Recommendation Report for Planning Permission for Works or Extension to a Dwelling

REF NO: AL/54/20/HH

LOCATION: Reed Cottage
Westergate Street
Westergate
PO20 3SQ

PROPOSAL: Garden shed and adjoining open potting area.

Reed Cottage : Shed and open potting area, Floor Plan

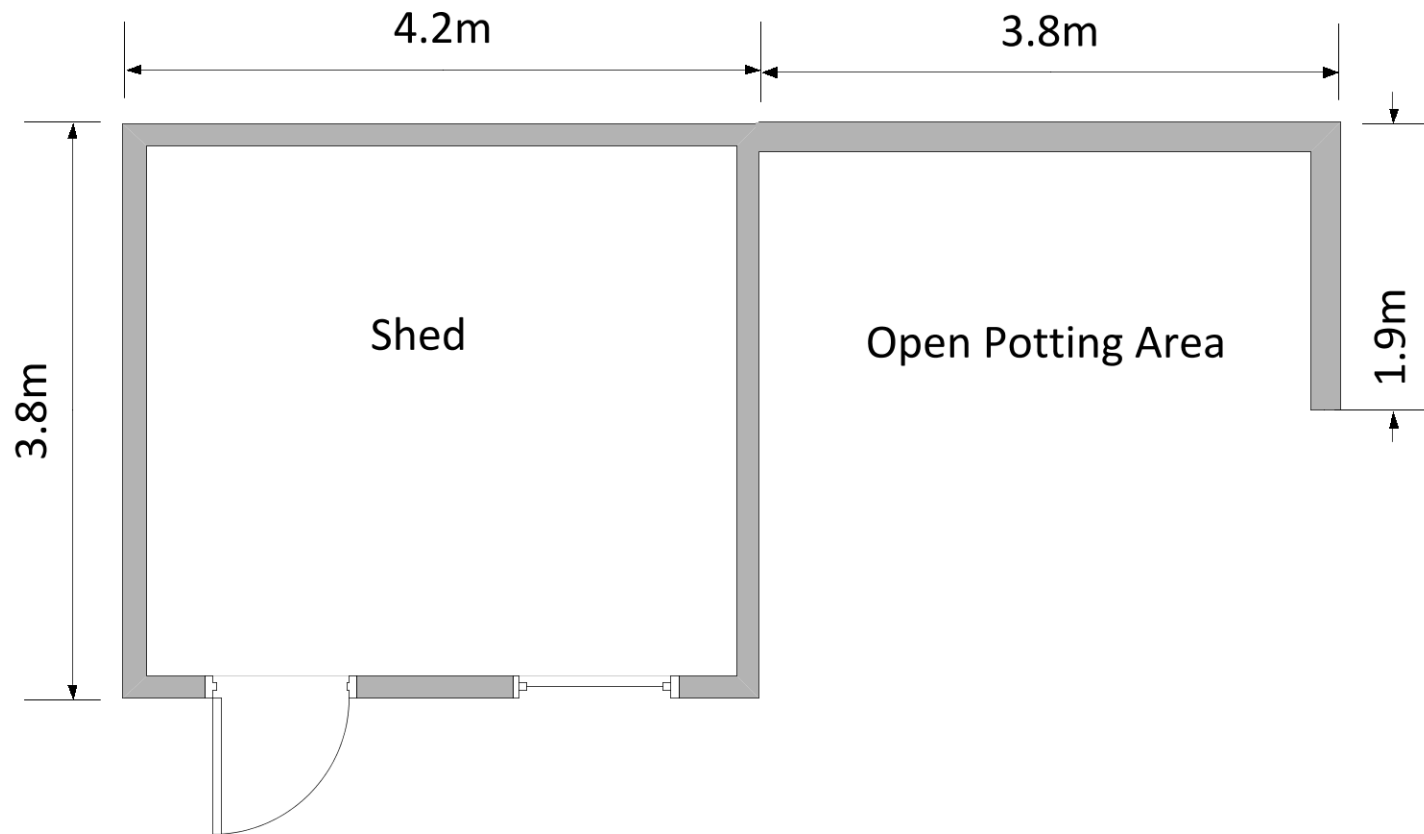
The outbuilding will run along the northern elevation with a width of 8m with 4.2m forming an enclosed shed area and the remaining 3.8m forming a potting area with the southern side open fronted.

The outbuilding has a width of 8m and a depth of around 3.4m which reduces to 1.9m to the eastern side. The outbuilding has a steep pitched roof with eaves to 2.4m and a total height of 4.8m.

To the north of the outbuilding sits the neighbouring dwelling 26 Belle Meade Close which has two windows to the ground floor southern elevation, serving a living and dining room. The outbuilding would only retain a minimum of 0.6m to the boundary.

Reed Cottage : Shed and open potting area, Front Elevation
(South)

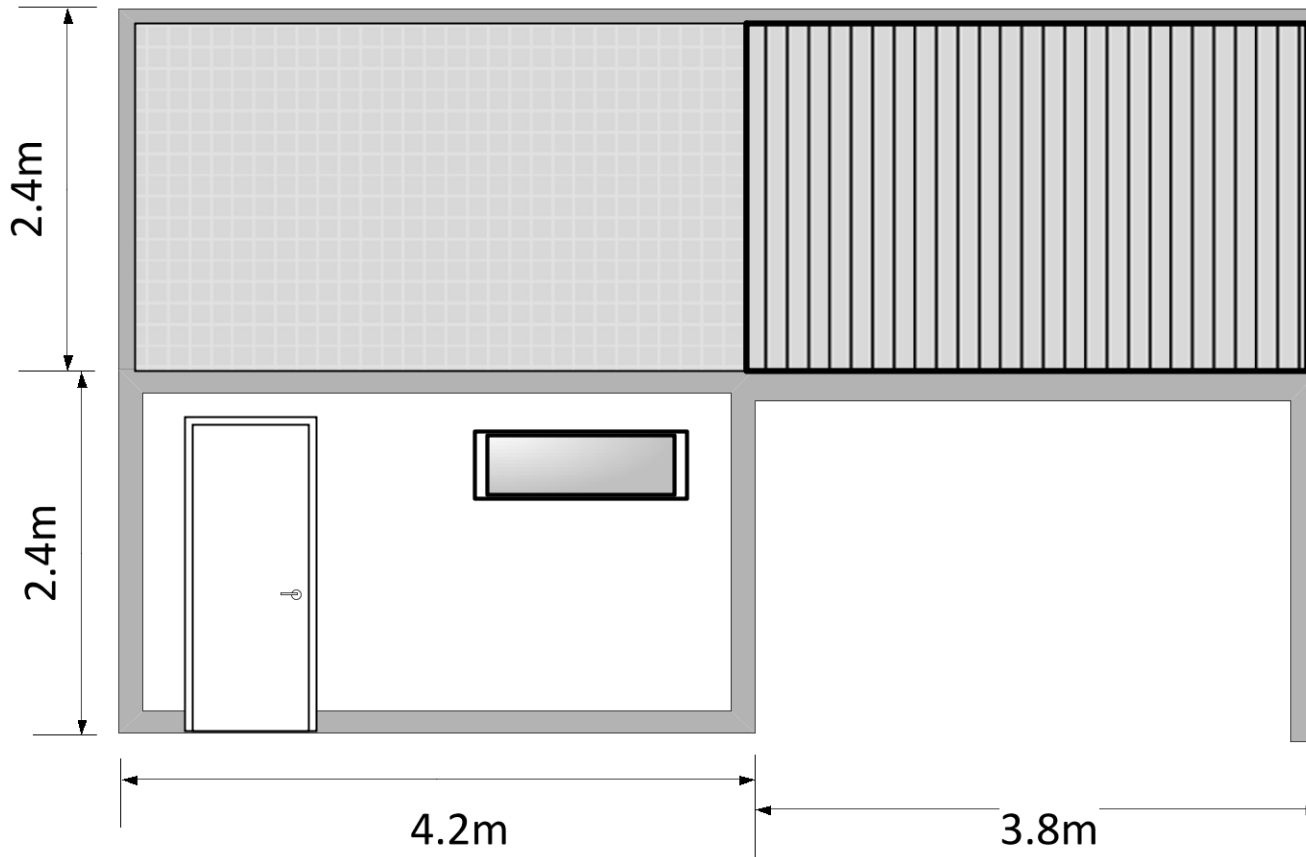
It will be constructed of part brick and wood with a steeply pitched tiled roof.

Due to the proximity of the outbuilding and the proposed height at 4.8m with the large expanse of roof, it is considered to appear as a dominating and overbearing feature upon the southern elevation of the neighbouring property. Having regard to this, it is considered an unneighbourly form of development. As a result the outbuilding would also give rise to a loss of light with the outbuilding overshadowing the windows to the southern elevation for most parts of the day.

Reed Cottage : Shed and open potting area, Rear Elevation
(North)

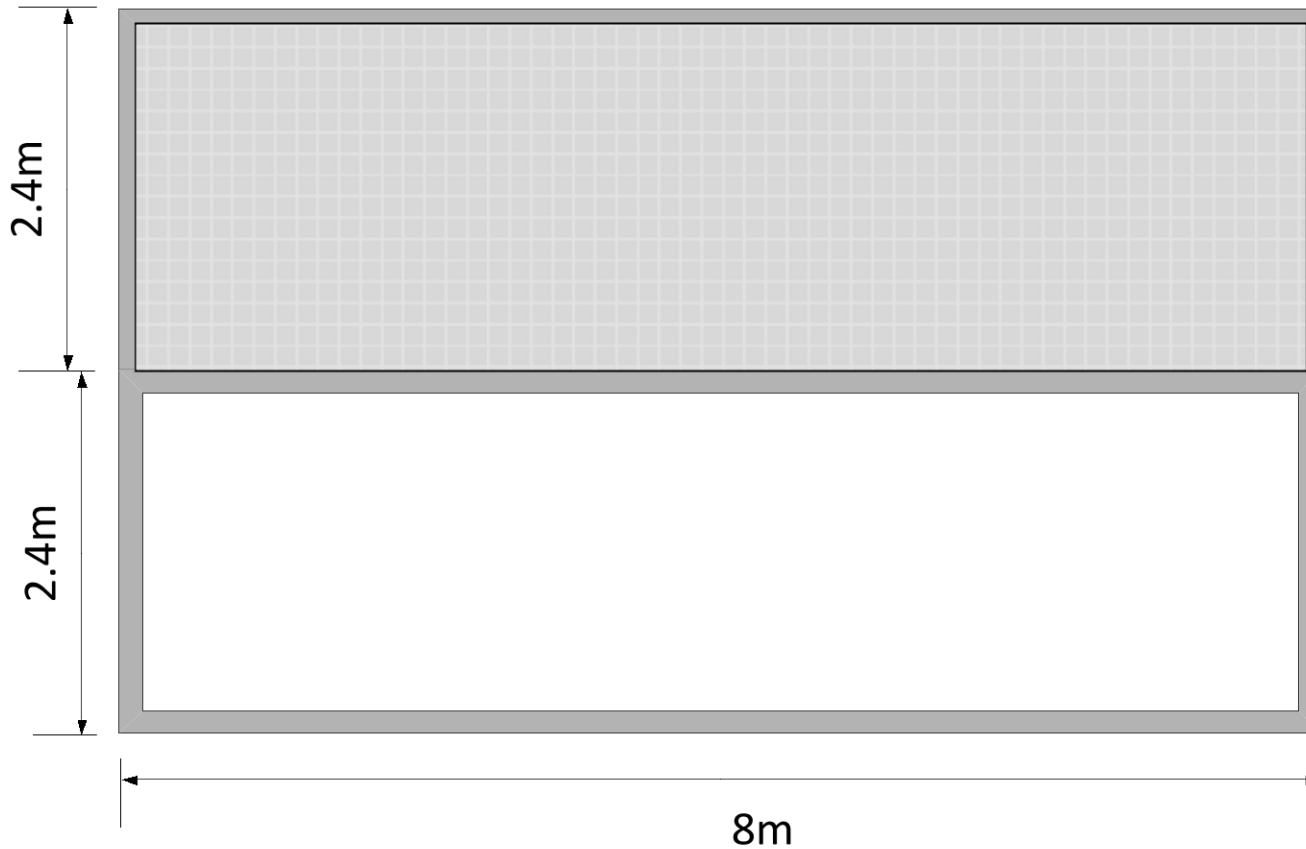
The property at No.26 has recently had permission for a first floor and if the extension were to be built the situation may be improved as it would consist of one larger room with openings at each end and a rooflight. However it can not be presumed that it will be implemented and as it currently stands the 4.8m ridge height would extend around 2.2m above the existing eaves of the neighbouring property.

The proposal as a result of the excessive height in close proximity to the neighbouring dwelling (No.26) would result in a significant loss of light to the windows to the southern elevation and result in harm upon amenity in conflict with D DM1 (3) of the Arun Local Plan.

- 1 The development by virtue of its excessive height and close proximity to the site boundary appears as a dominant and overbearing feature resulting in significant overshadowing to the southern windows at the neighbouring property (26 Belle Meade Close) in conflict with D DM1 (3) of the Arun Local Plan.
